PLANNING CONSULTATION RESPONSE

Application No	2026/0722
Proposal	The installation of a multifunctional communication Hub including defibrillator and advertisement display, as illustrated in the attached documentation (Advertisement Consent)
Address	Outside 22 May Day Green, Barnsley, S70 1SH
Date of Consultation Reply	23/09/26
Consultee	Highways DC

SITE PLAN & IMAGES

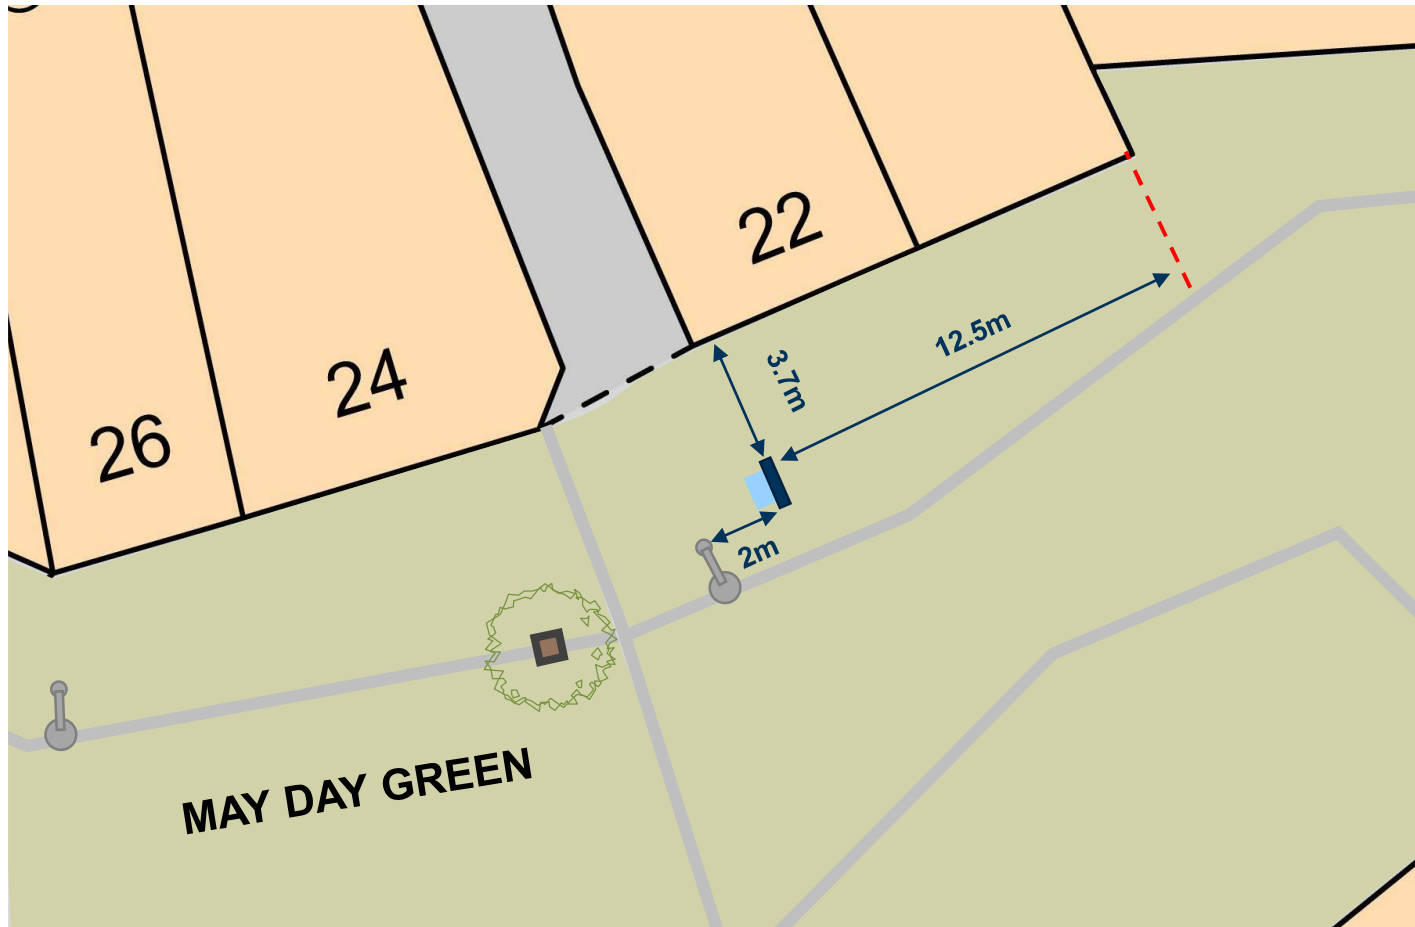
The Street Hub is positioned away from the access route through the precinct and would not impede pedestrian movements with ample width being retained.
